BE/79/15/NMA

**Application for Non Material Amendment
Planning Decision Reference: BE/23/14/PL**

This application is to extend the front elevation cladding system to the base of the wall, and largely omit the brick wall.

drawing title:
Elevations as Proposed

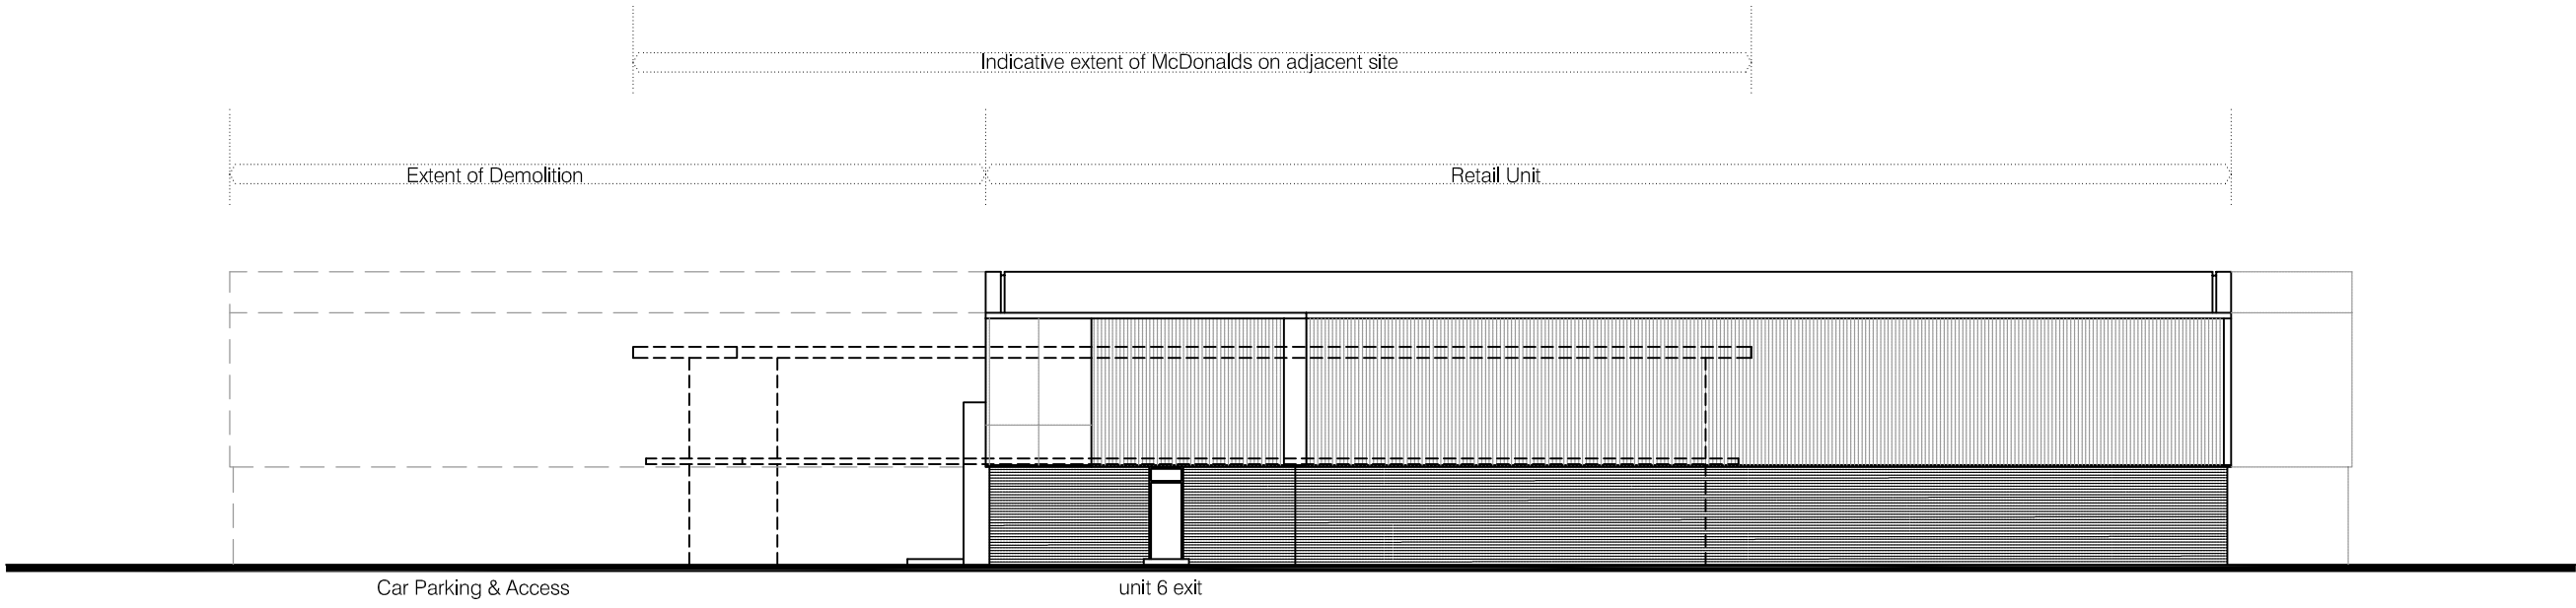
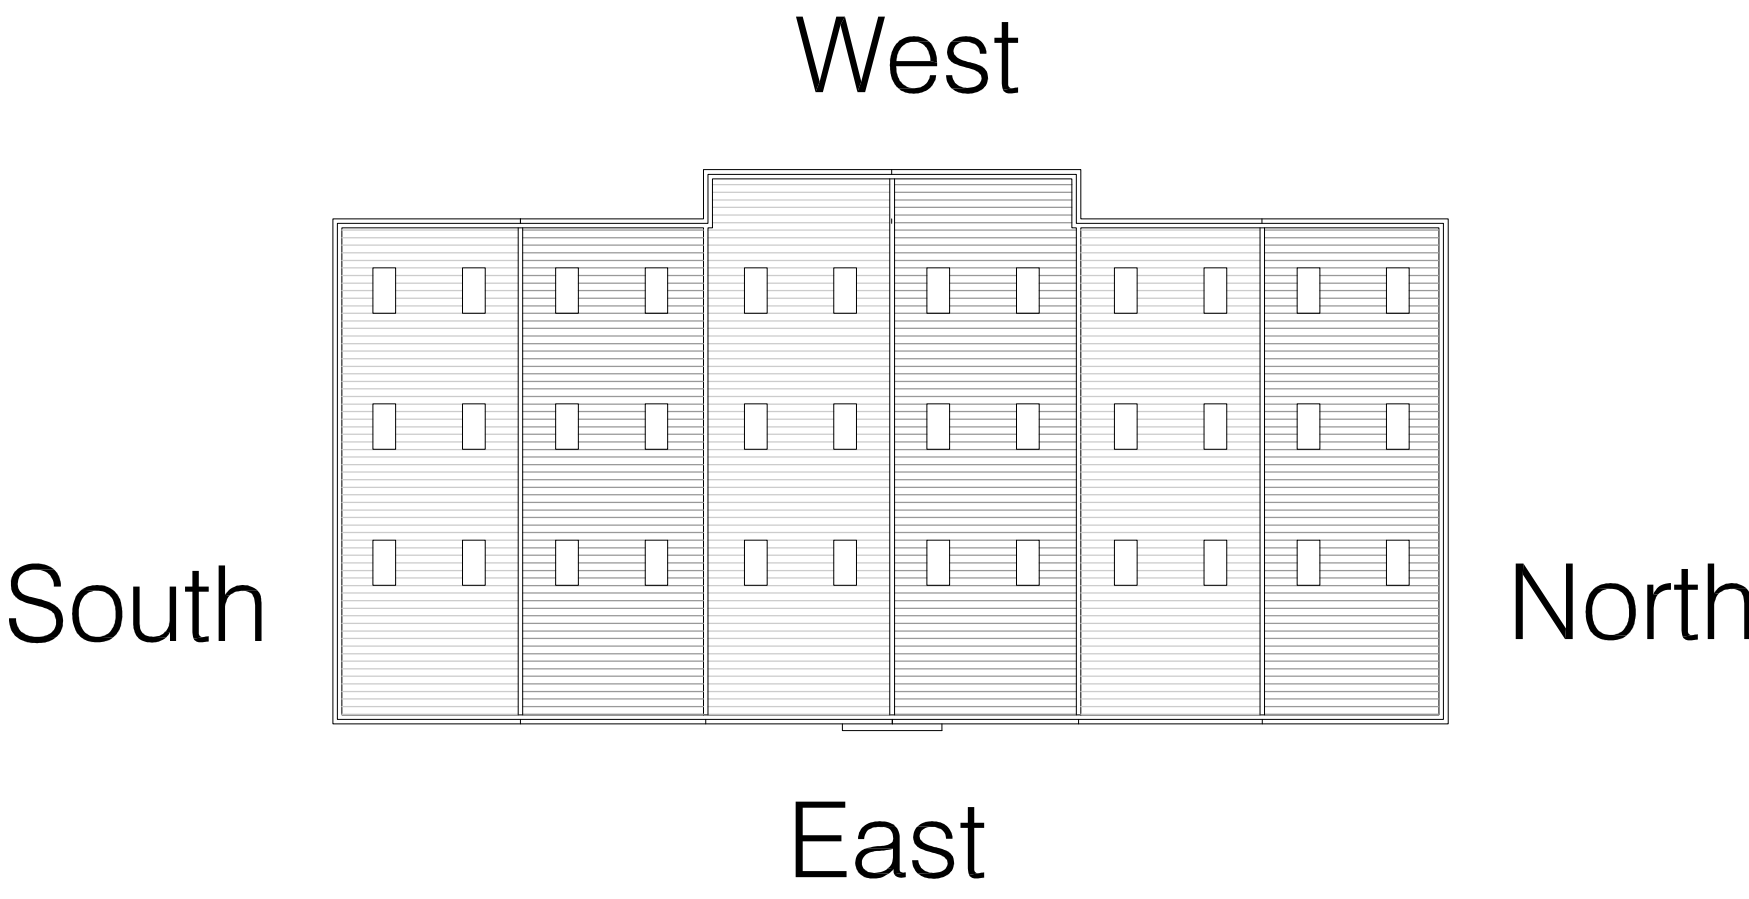
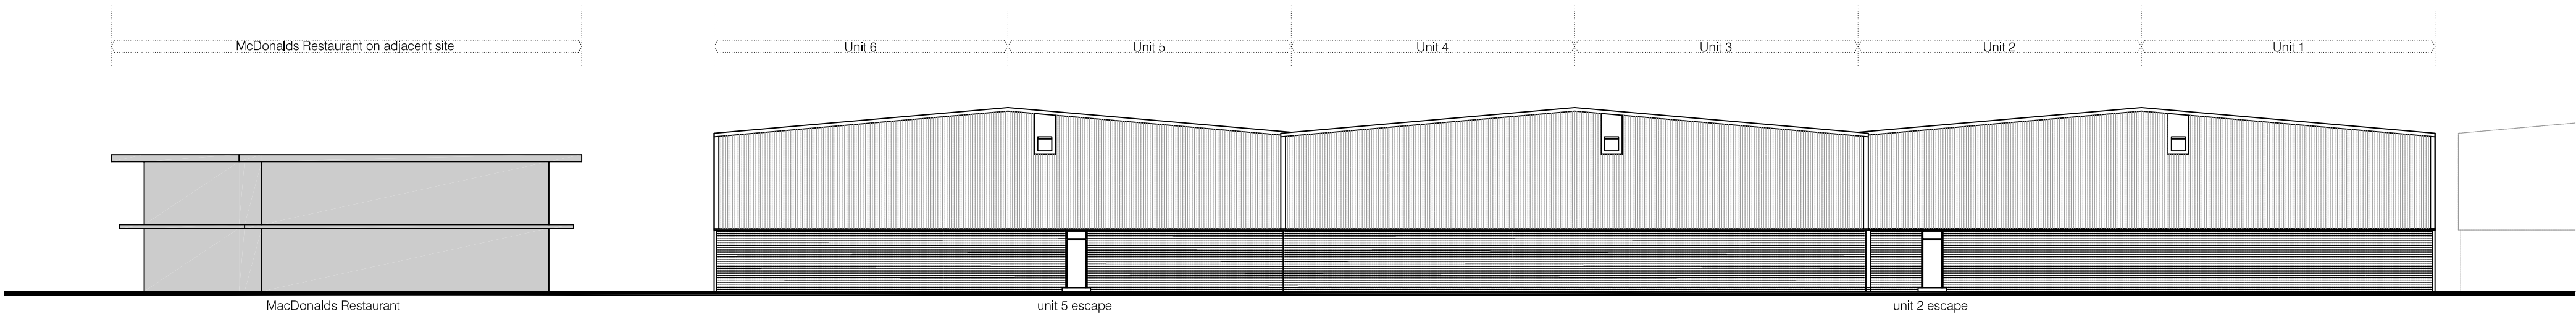
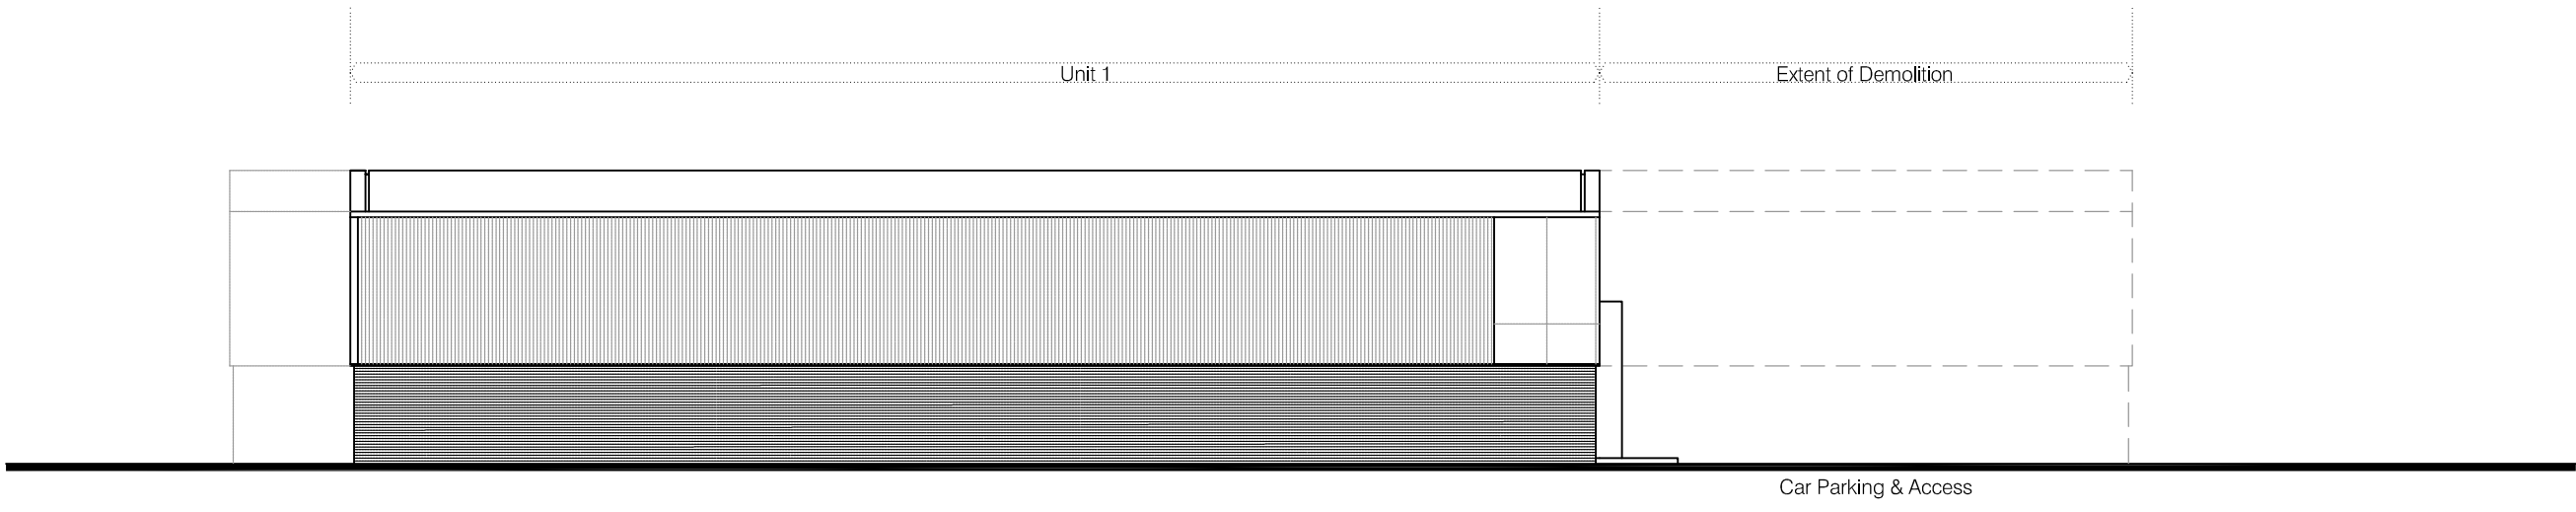
This application is in accordance with and does not alter the previously issued schedule of materials and finishes which is supplied with the Discharge of Planning Conditions, the brickwork is just getting smaller.
